STATE SIGNIFICANT DEVELOPMENT APPLICATION (SSD 9429) FOR PROPOSED WAREHOUSE AND DISTRIBUTION FACILITY (SNACK BRANDS)

PROPERTY AT: LOT 7, 585-649 MAMRE ROAD, ORCHARD HILLS (LOT 2171 DP 1153854)

Table 1: Response Matrix	
Relevant Entities Response to Submissions	Formalised Response
NSW Department of Planning & Environment (Kelly McNicol – Team Leader, Industry Assessments)	
<p>Height:</p> <p>1. Page 4 of the RTS states:</p> <p><i>"The proposed building height is for approximately 36.8 m at the ridge height as per the architectural plans. Appendix 21 regarding the proposed ASRS relates to the proposed racking within the proposed high bay warehouse, which attains a height of approximately 30 m; hence the 6.8 m balance. No further consideration is required in this respect."</i></p> <p><i>The intent of the Department's initial question regarding the 6.8 m height balance was to understand why this difference between the ASRS and the ridge of the warehouse structure is proposed. As it stands, it appears there is 6.8 m of unused and unnecessary height between the top of the ASRS and the highest point of the warehouse and the overall height of the structure could potentially be reduced. Th

Drawing Title:
Landscape Sections - AA & BB
DWG No:
SSD-02

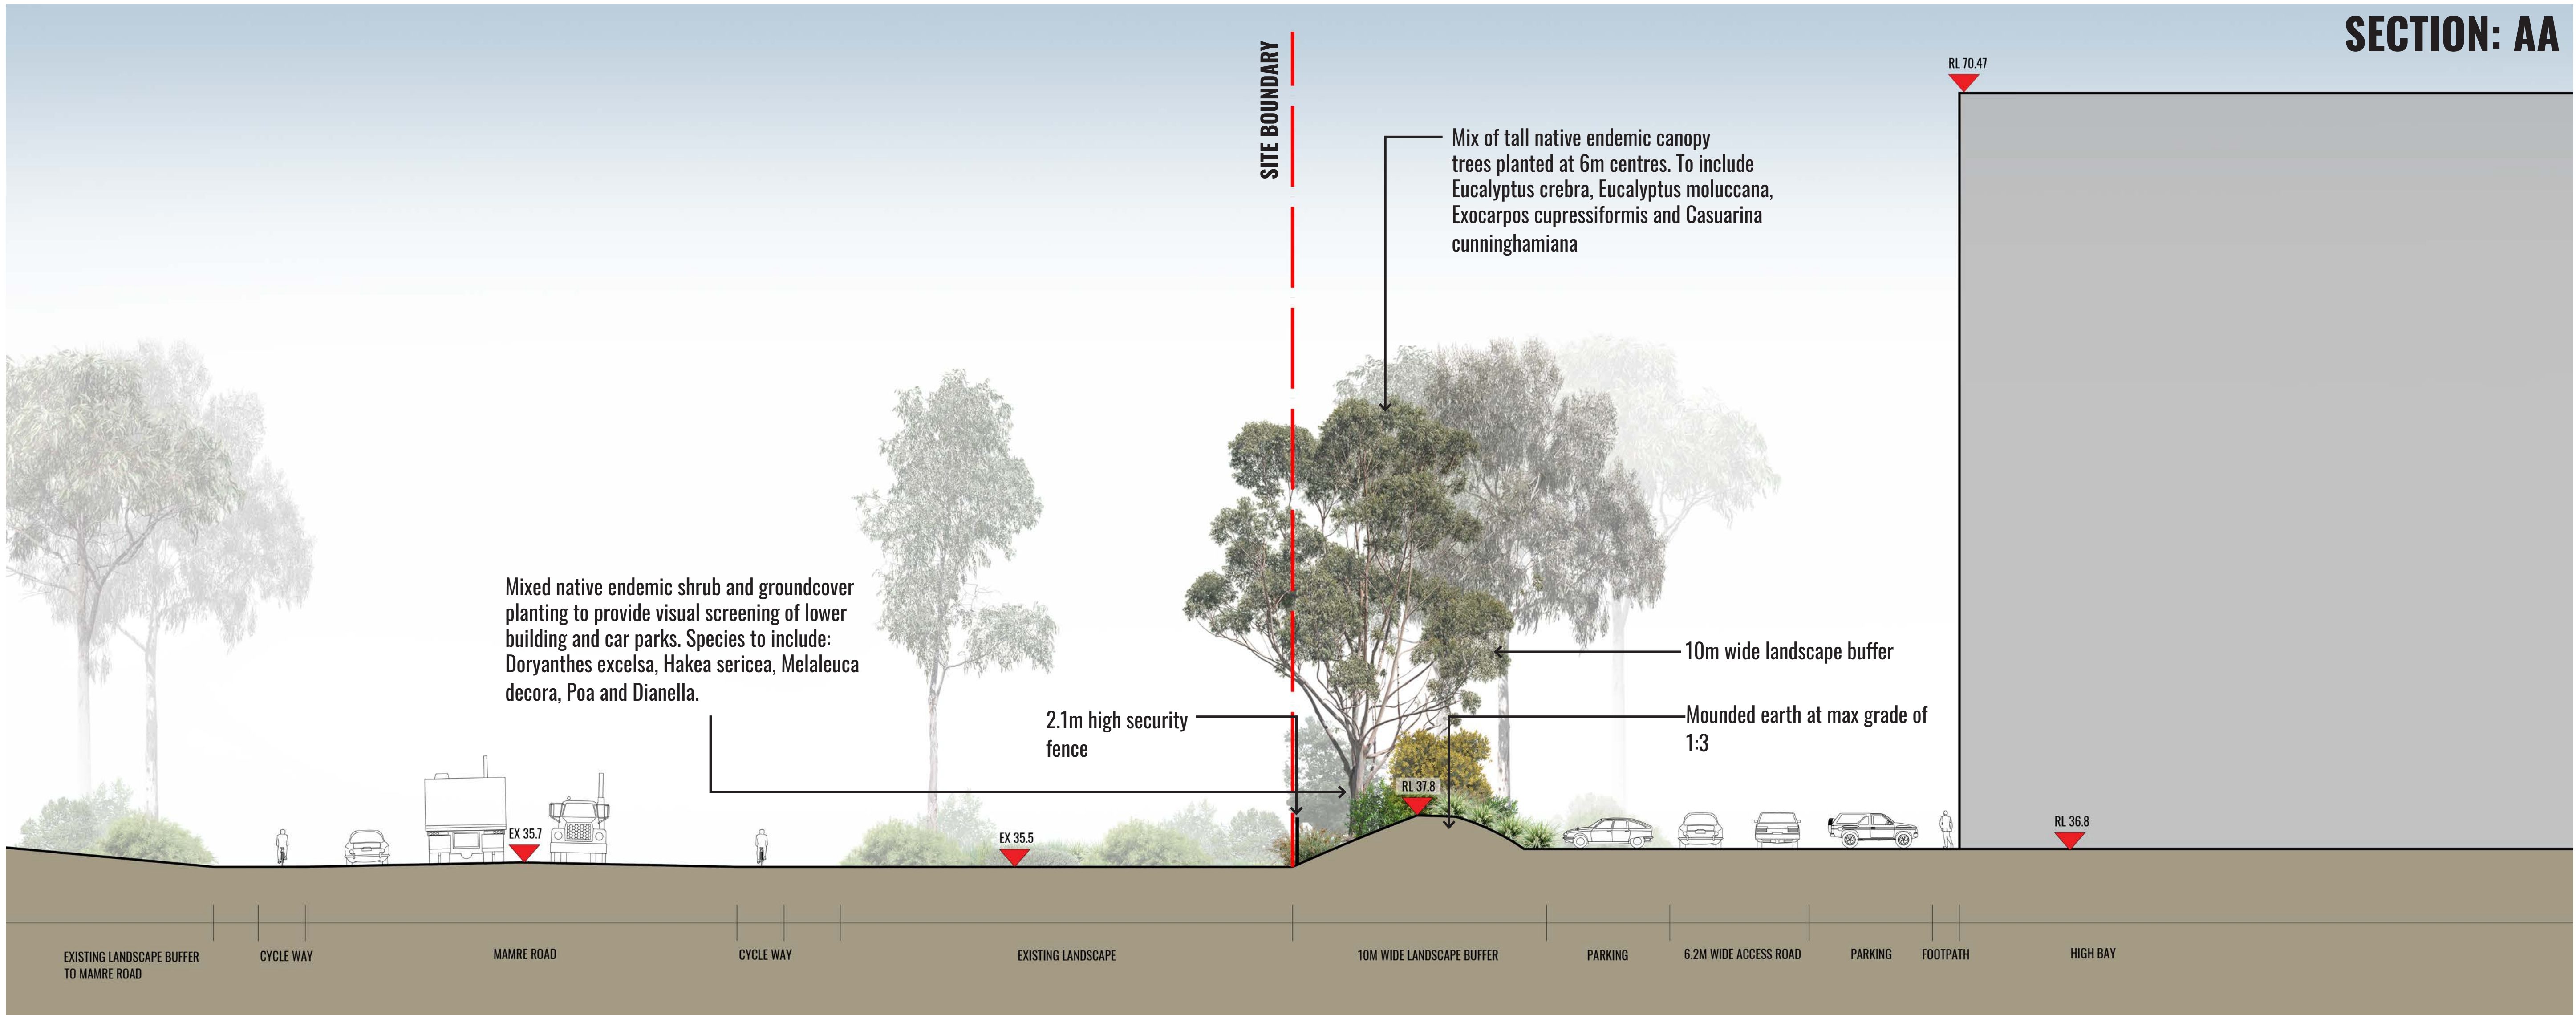
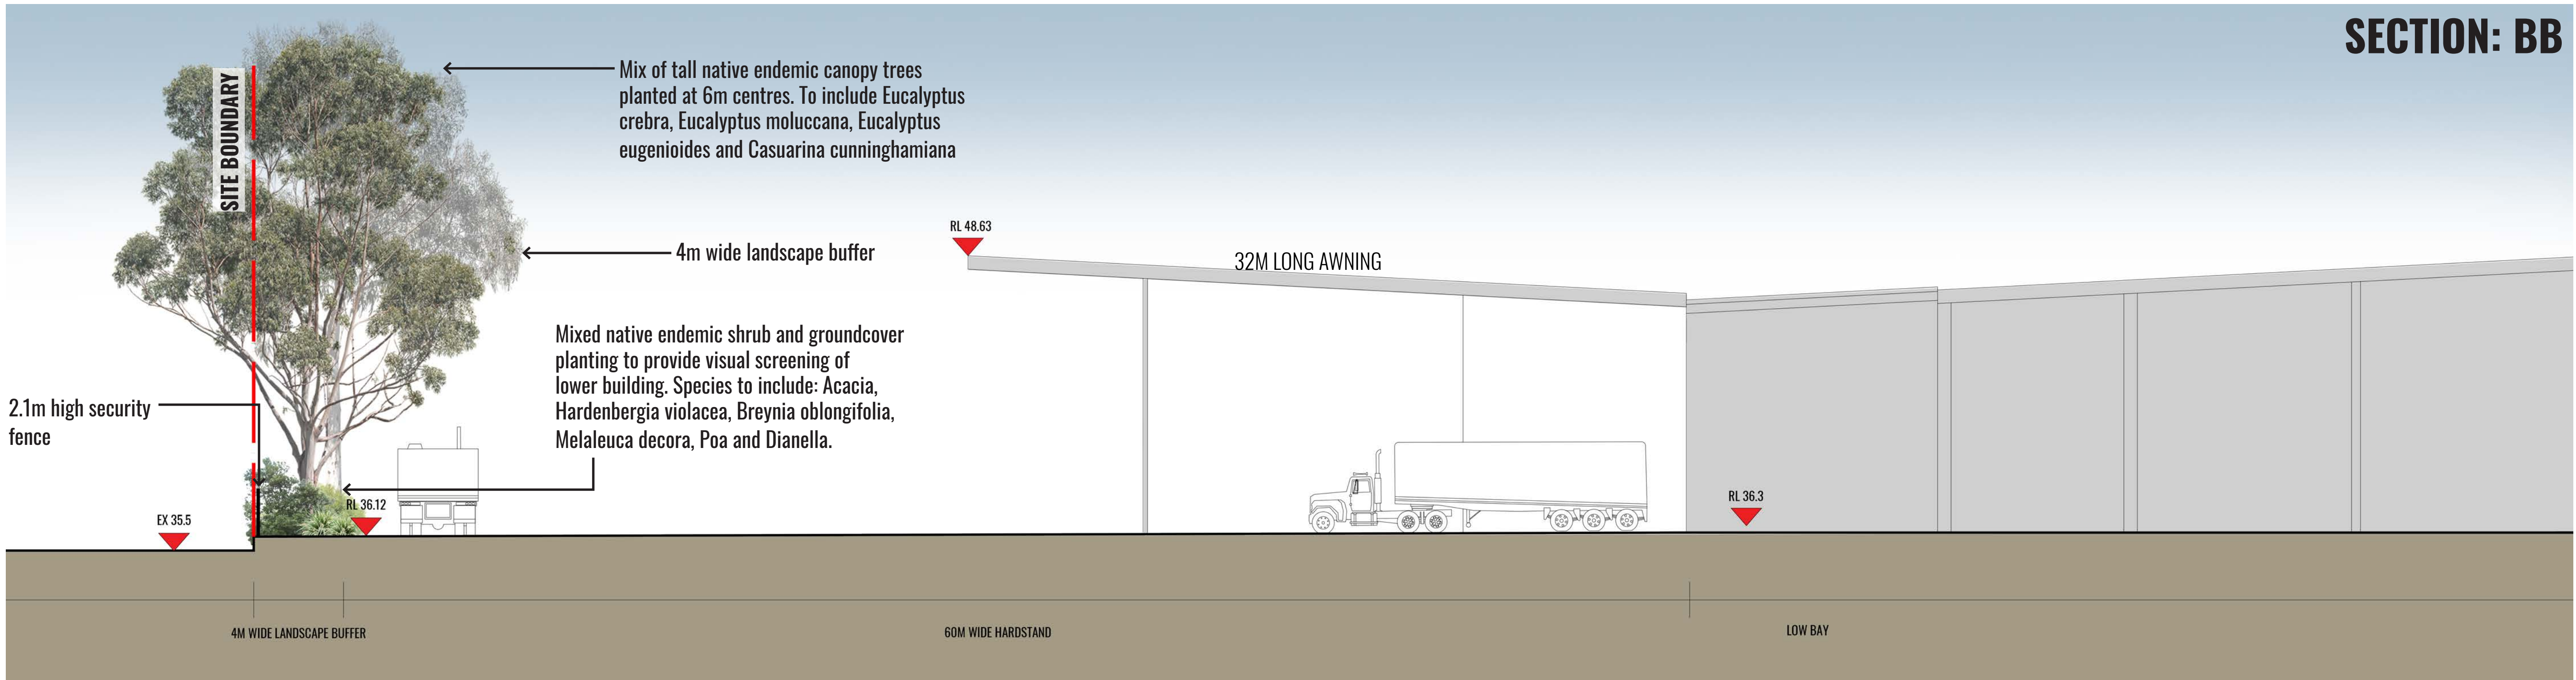
<p>Landscaping:</p> <p>4. <i>Provide the approximate height of the proposed landscape mound.</i></p> <p>5. <i>Will the proposed 2.1 m high palisade fence be located behind the proposed landscape planting, when viewed from the street? The</i></p>	<p>The Mamre Road frontage landscape mound is approximately 2-2.5 m above the undulating existing ground line at the boundary and approximately 1-1.5 m above the carpark, adjacent to the proposed facility; and, accommodates the change in level between the road widening reserve and the building platform.</p> <p>Additionally, the Distribution Drive frontage landscape mound is approximately 1.5-2.0 m above the road and carpark adjacent to the proposed facility.</p> <p>The landscape mound is further illustrated within the updated Landscape Plans located within Appendix 2 of this Submission.</p> <p>The fencing proposed along the Estate Road (Distribution Drive) will be located behind the proposed landscape planting and in line with other warehouses</p>
